Consultation Response from KC Conservation and Design
2019/93284 Clayton West United Reformed Church, Church Lane, Clayton West, Huddersfield, HD8 9LY
Alterations to convert former church to 6 dwellings
Date Responded: 02.12.19 | Responding Officer: Sue Oakley | Responding Ref:

DRAWING TITLE: PROPOSED ELEVATIONS & SECTIONS

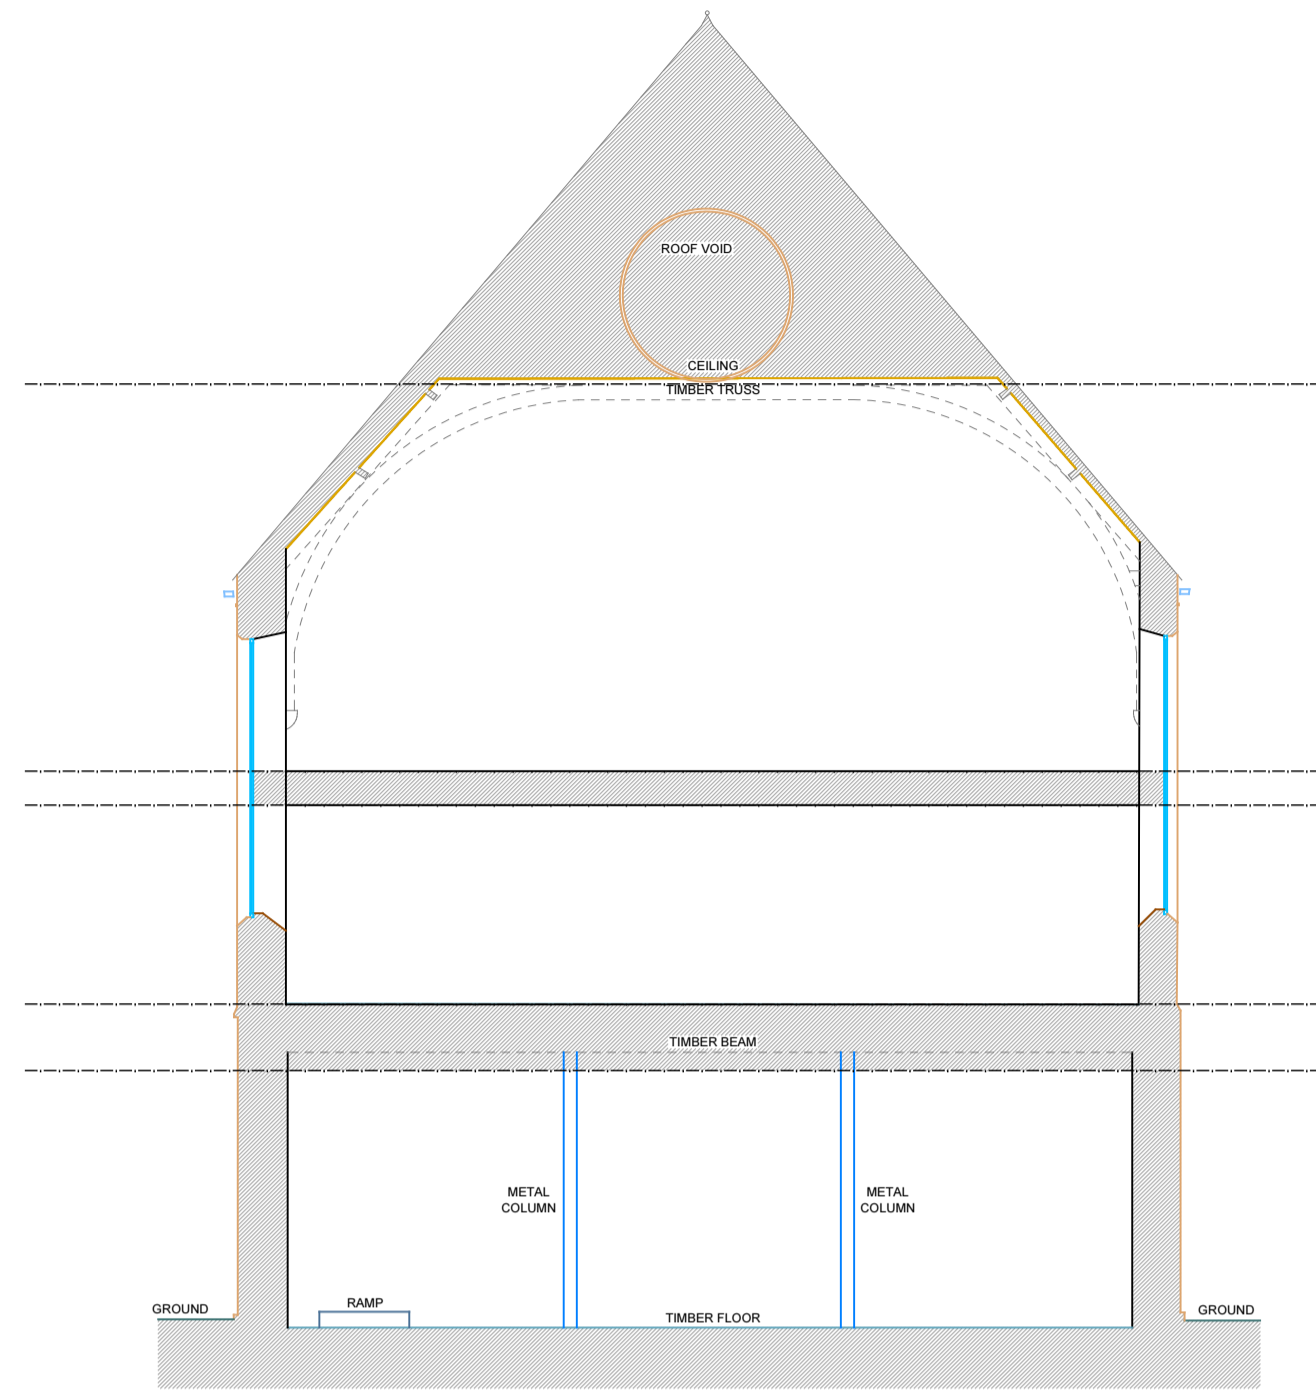
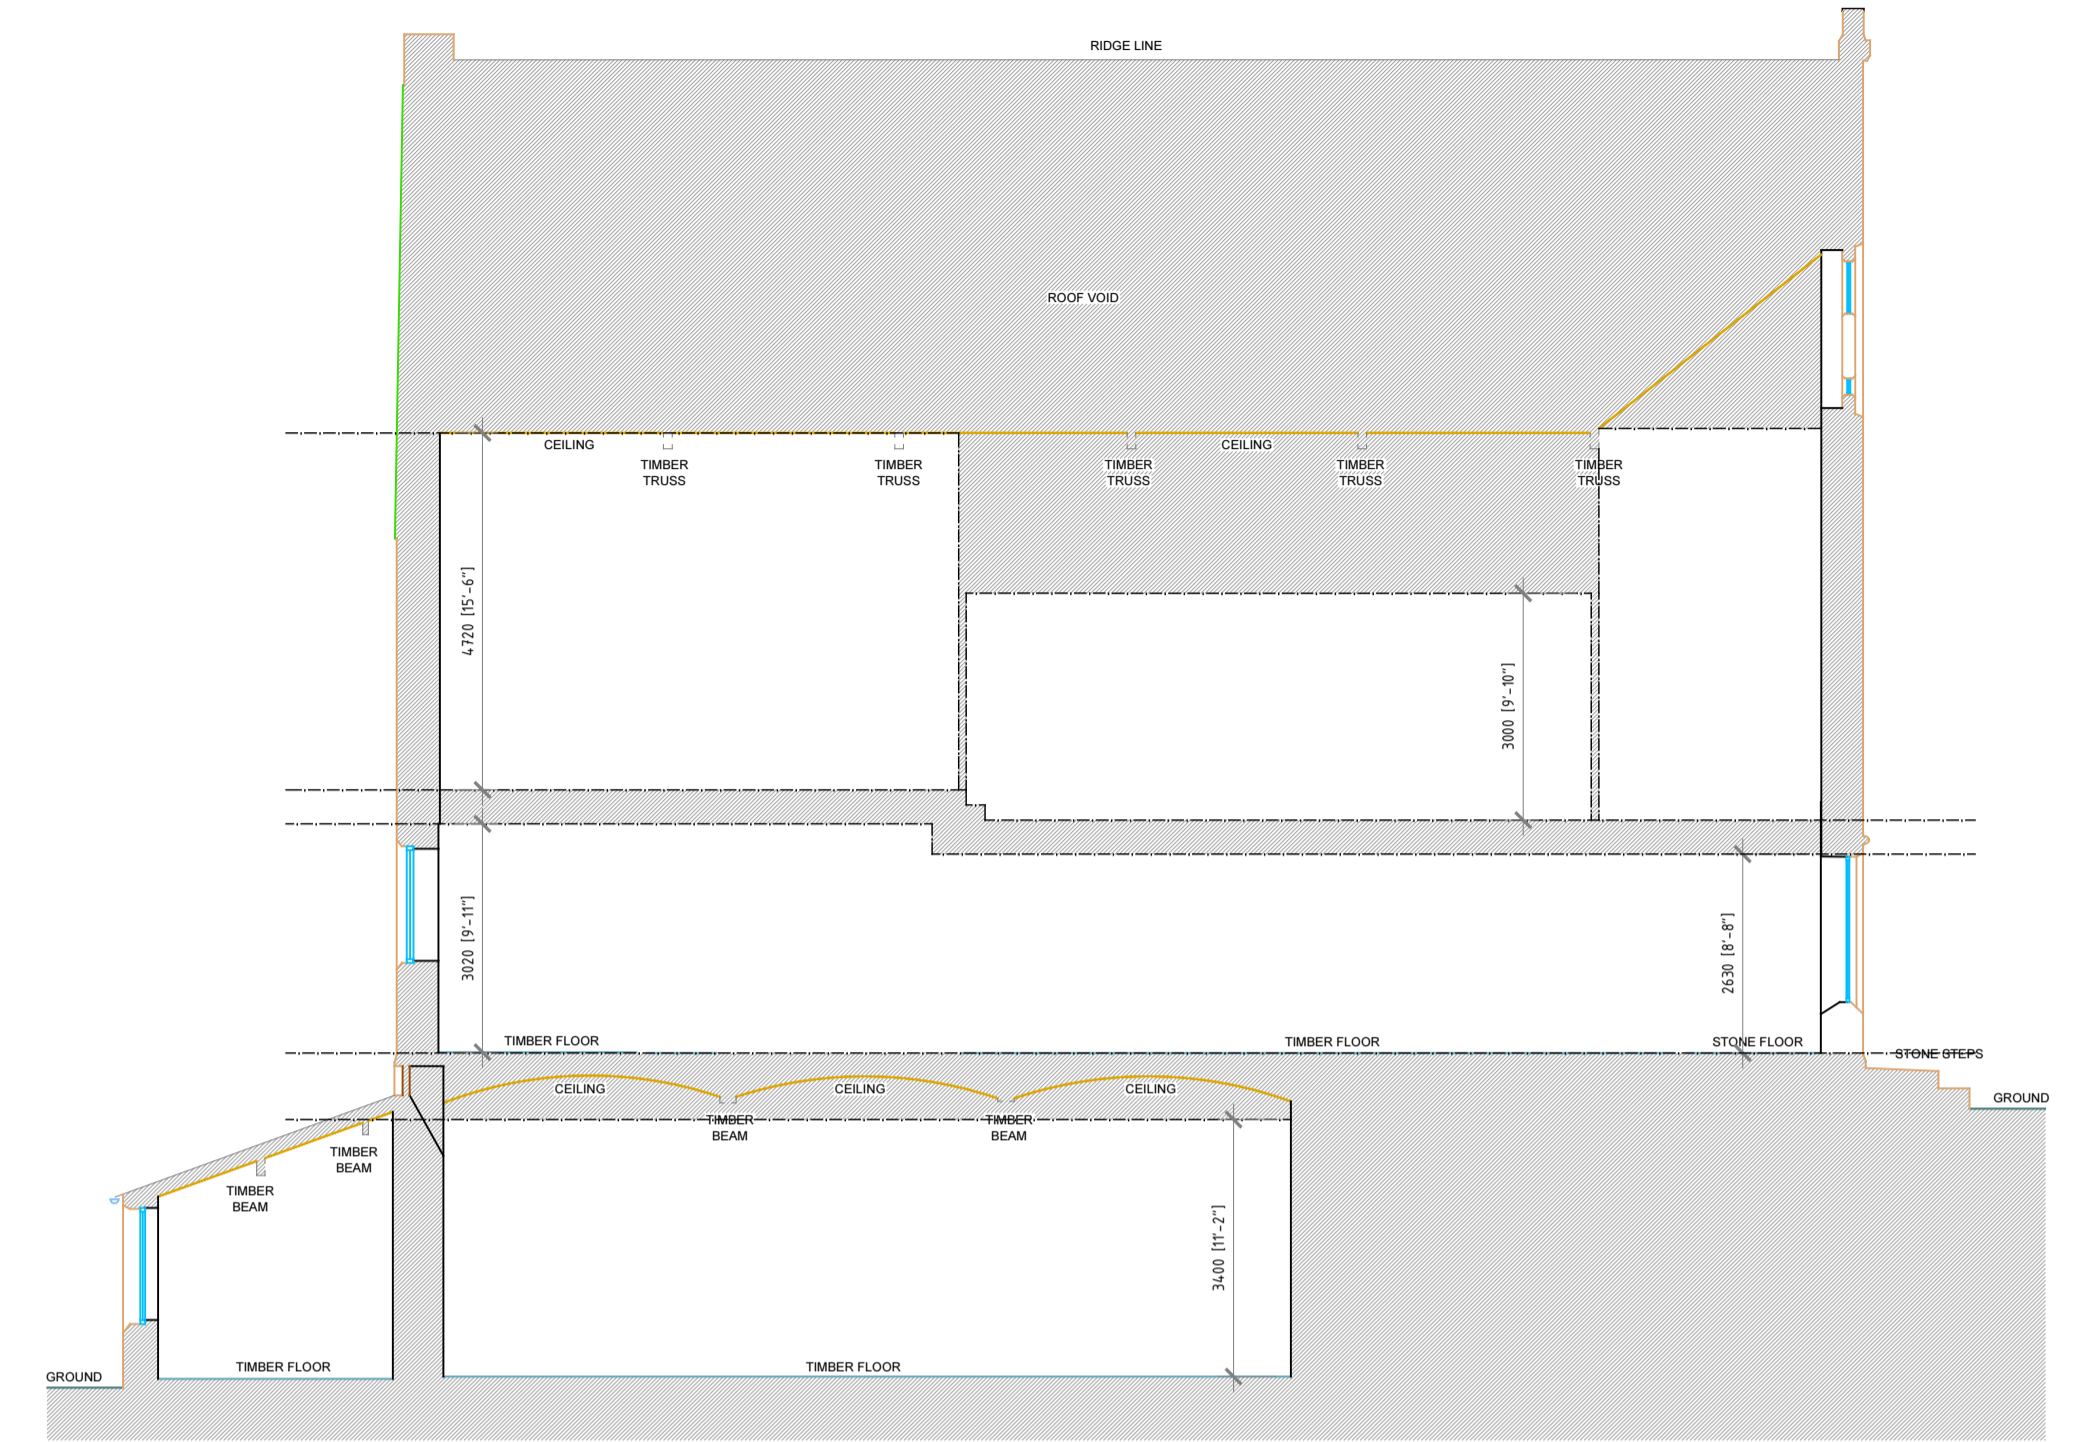
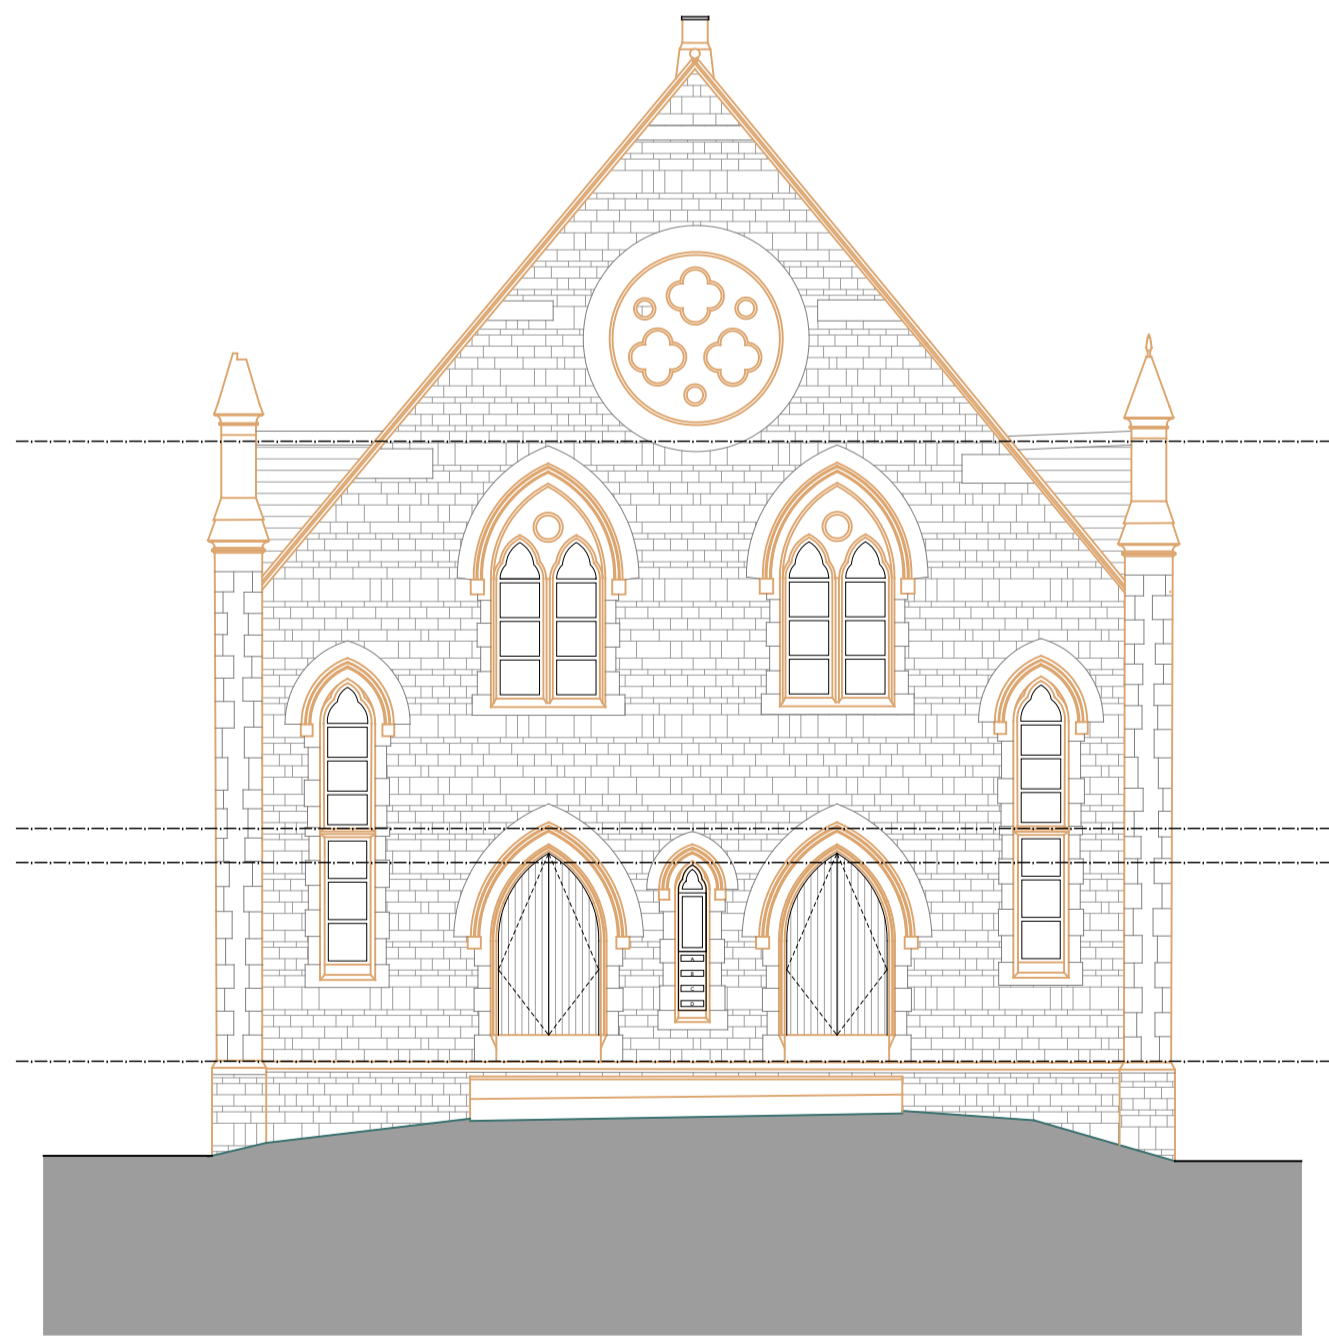
With the exception of the rear elevation, the external fabric of the building will remain predominantly unaltered, although the existing windows will be replaced with anthracite grey uPVC windows and with grey composite doors on the side and rear of the building. A number of new window openings are proposed in the rear elevation and these are simple in design and I do not consider these to harm the character of the building. They should be set into ashlar stone surrounds to match the existing windows on this elevation.

I would prefer all new window frames to be slim in section to minimise their bulk and retain the character of the building, particularly on the façade, and I would suggest that window details should be submitted for approval prior to manufacture.
